**COUNCIL OFFICE EXTENSION – N6/2013/1938/MA**

I write to object to aspects of the Council's proposed extension.

Title Proposed Materials

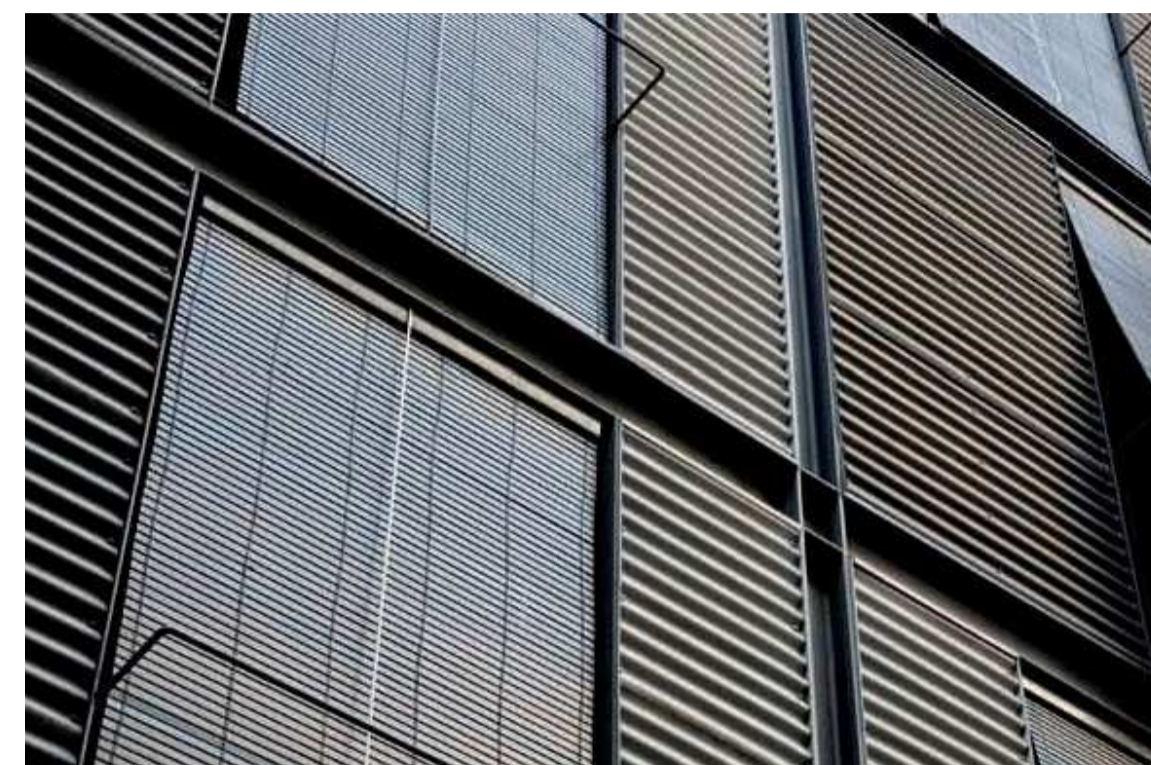
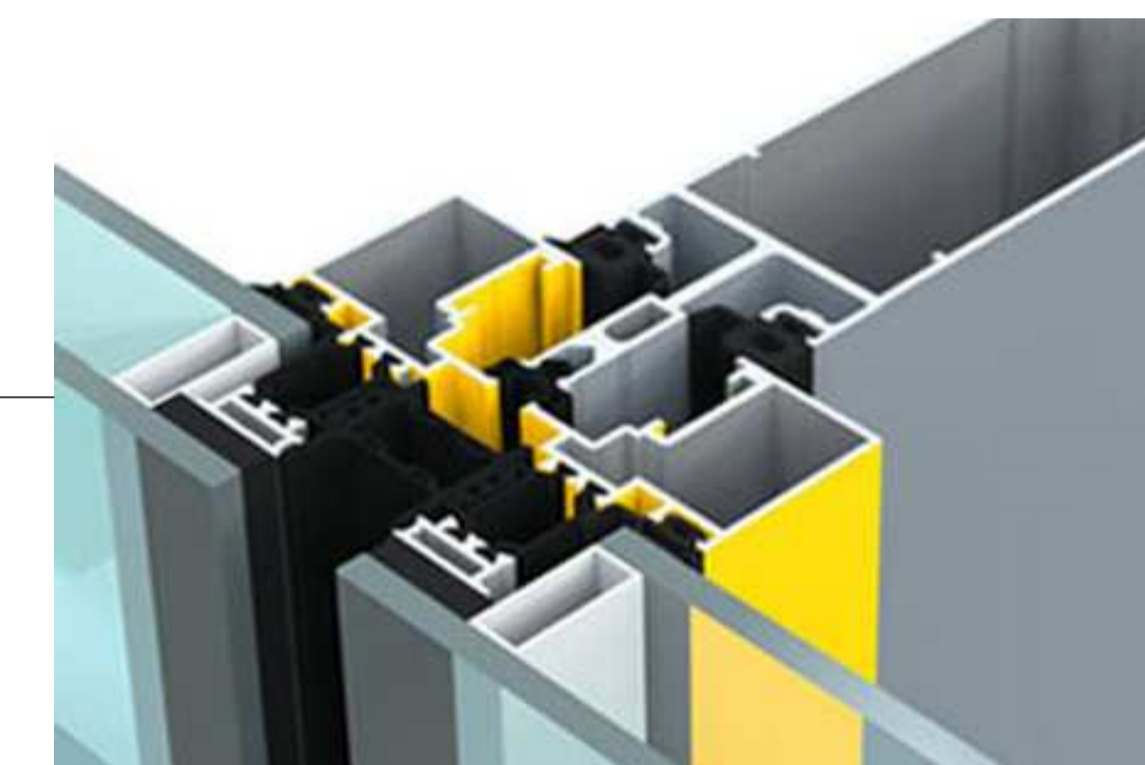
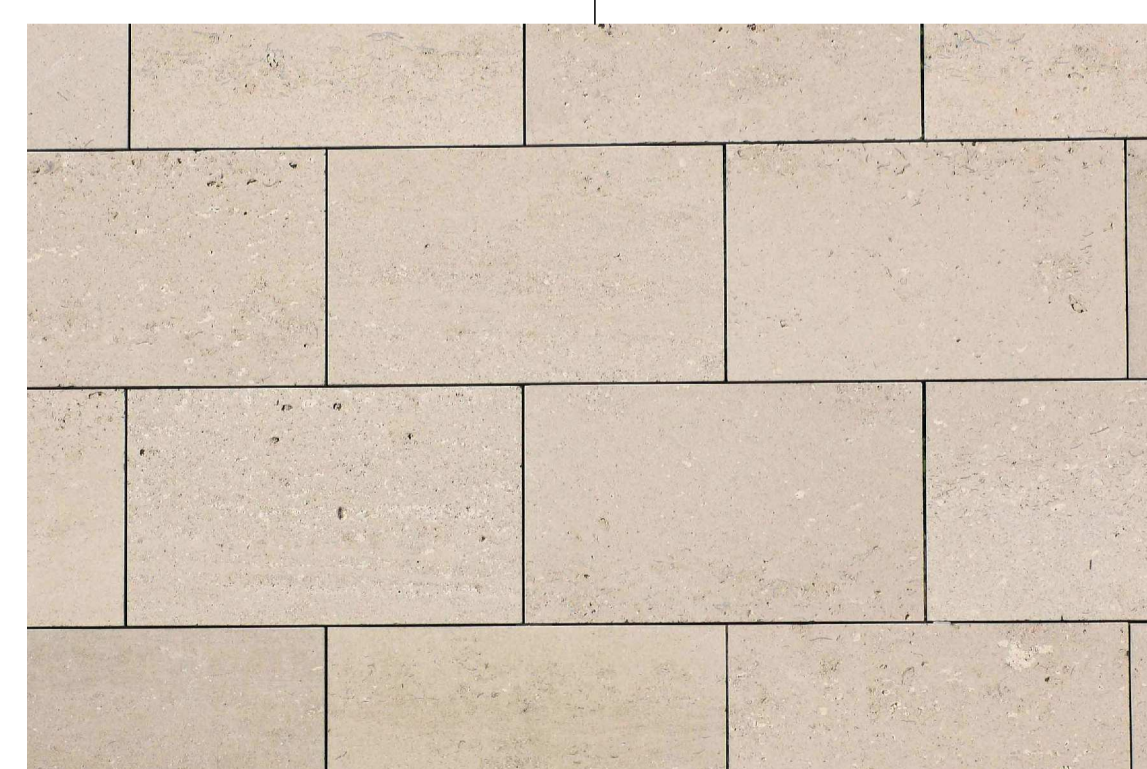
My objection is to the façade of the 'Council Chamber Entrance' shown on the planning application. The use of such a large scale glazed façade is not in keeping with the Garden City ethos or the Estate Management Scheme. Policy EM1 covers extensions and alterations to existing properties and I believe that the proposed glazed façade is in clear contravention of this Policy. Whilst recognising that Policy EM1 is focussed on residential properties, the Policy wording does not appear to restrict its application solely to residential properties. In any case the Policy does no more than express what would be considered good architectural practice in a conservation area.

In my opinion the façade should comprise brickwork and fenestration 'in keeping with the existing building.'
